Rezoning Transportation Analysis

Petition Number: 2021-086

Date	Description
08-02-2021	First Review (DBS)
08-23-2021	Second Review (WB)

DEVELOPMENT STANDARDS

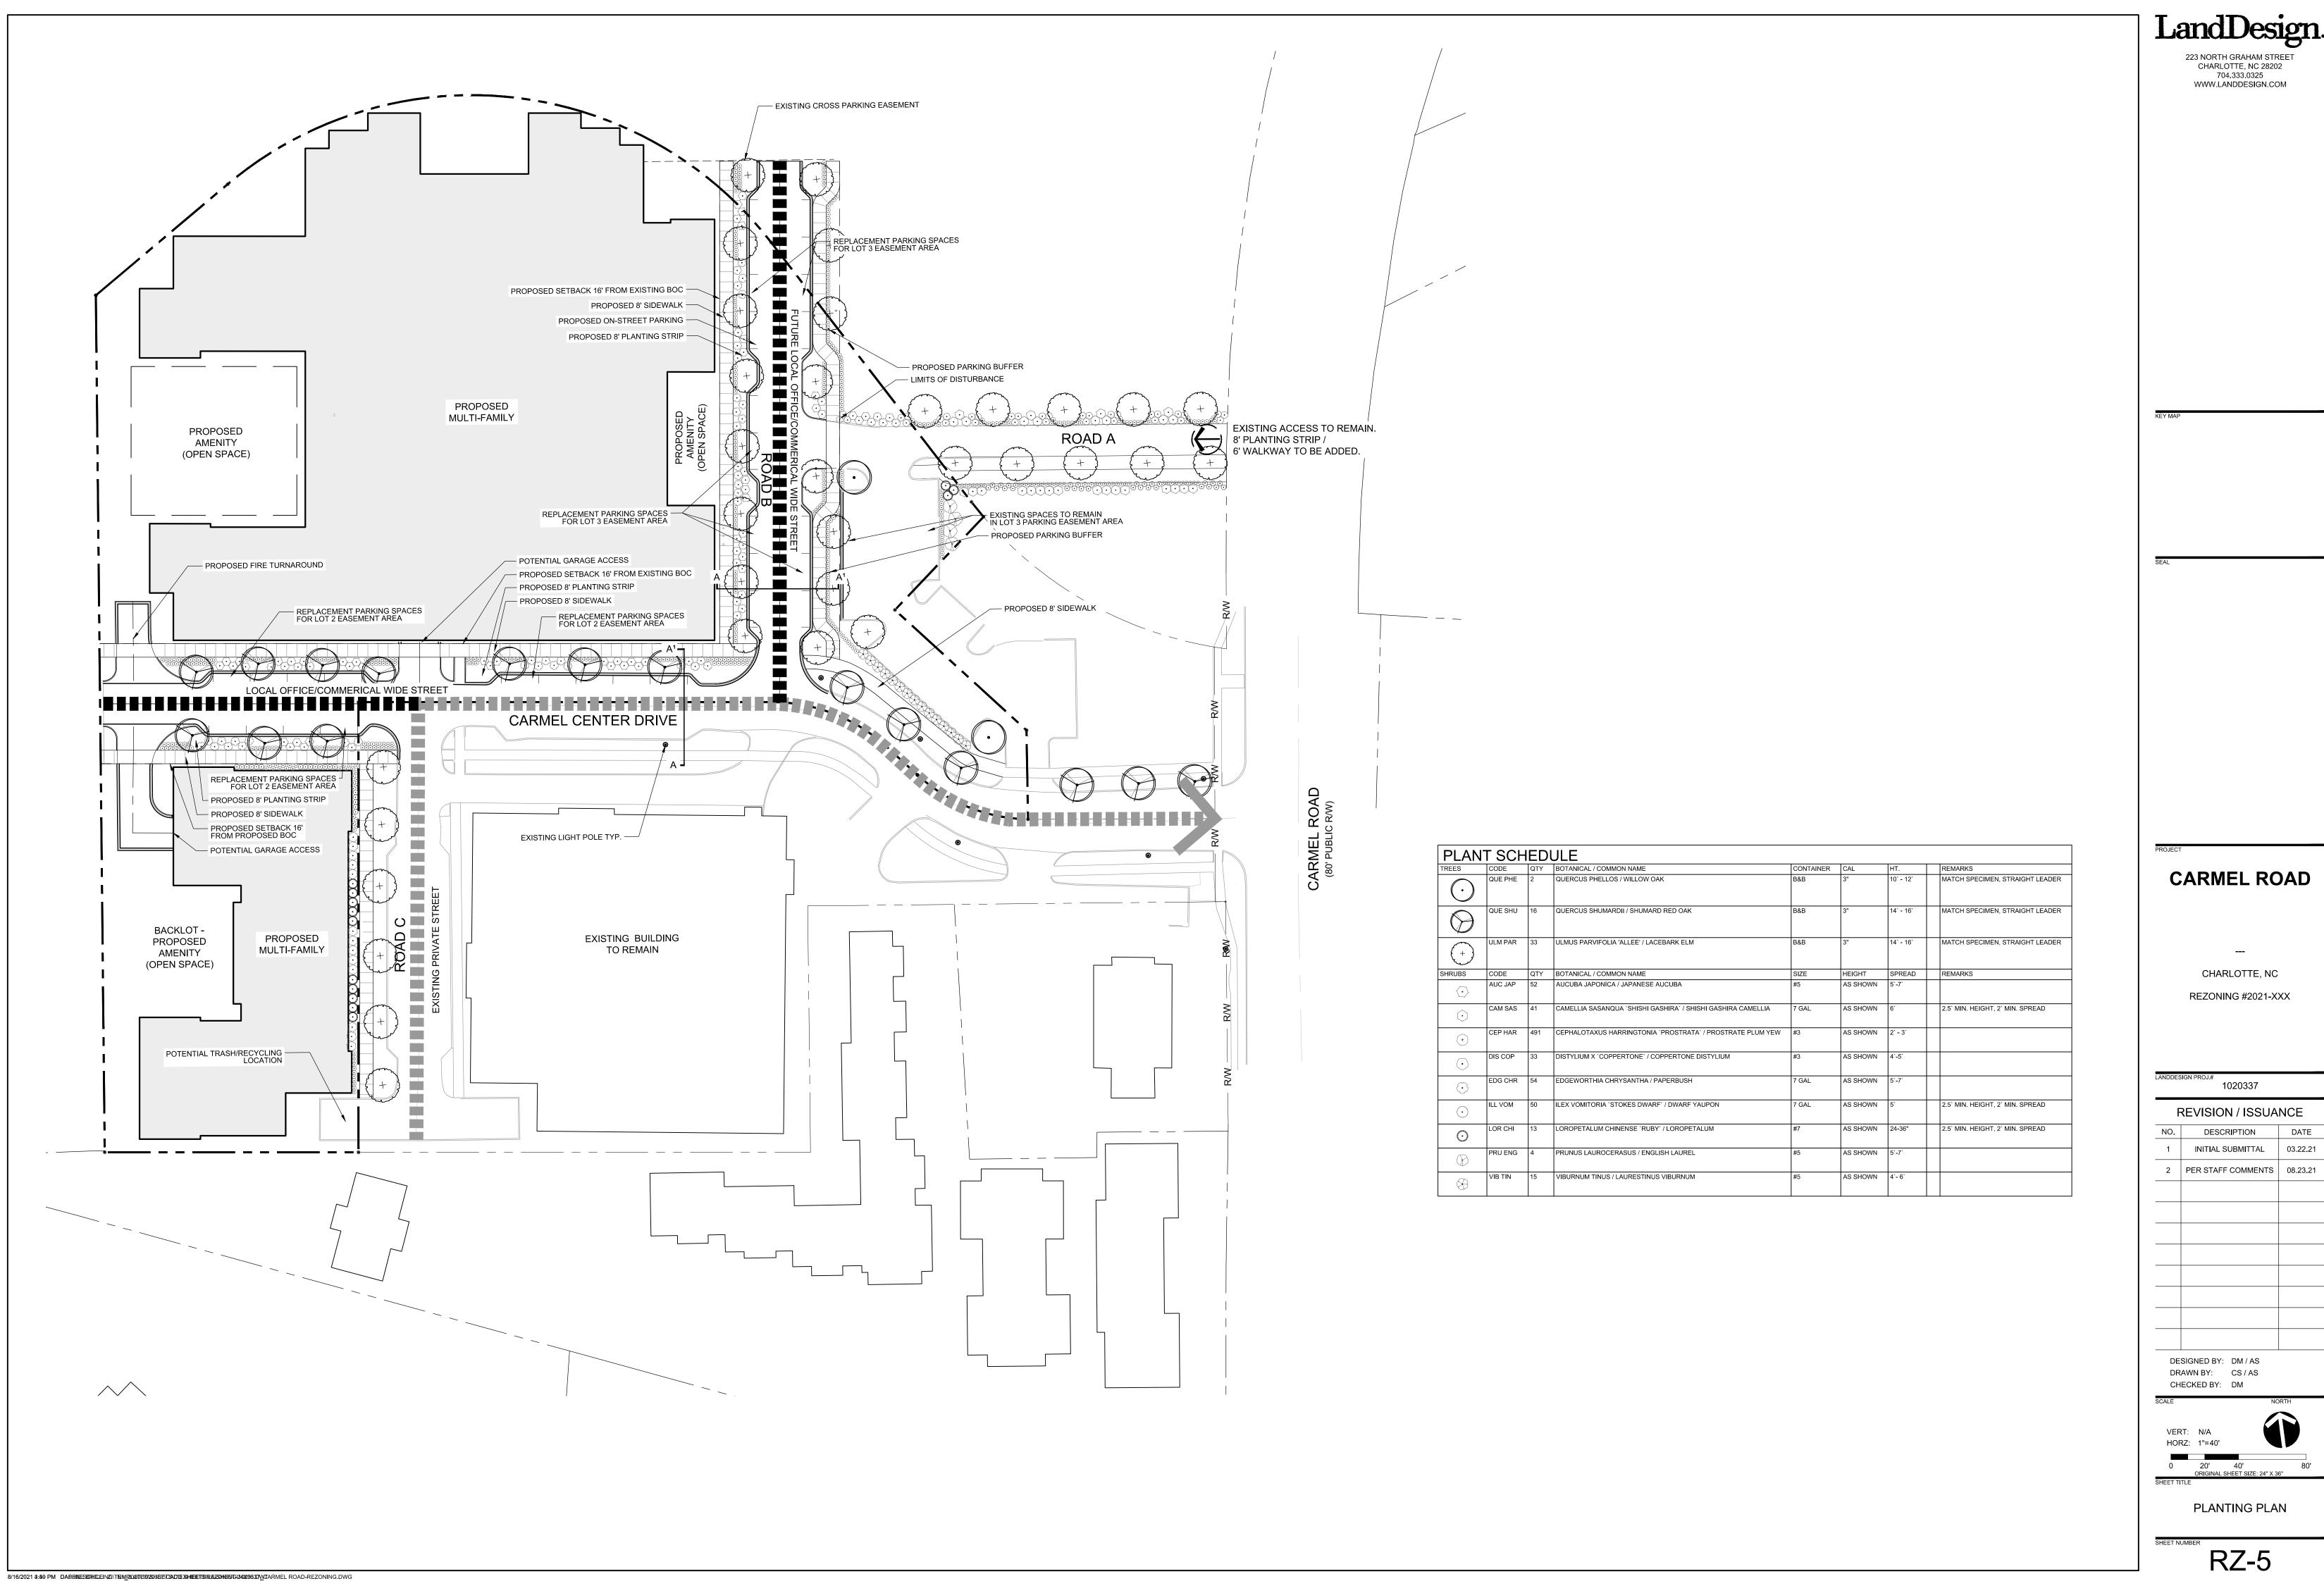
- ~~1. A Traffic Impact Study (TIS) is not necessary for the complete review of this petition due to the site generating less than 2,500 daily trips. If during the permitting process the site generates more than 2,500 daily trips, then a traffic study will be required.~~
2. Site plan and conditional note(s) revisions are needed to clarify that the transportation requirements approved in RZ-2017-021 are still in force and that off-site parking requirements cannot be met by on-street parking spaces.
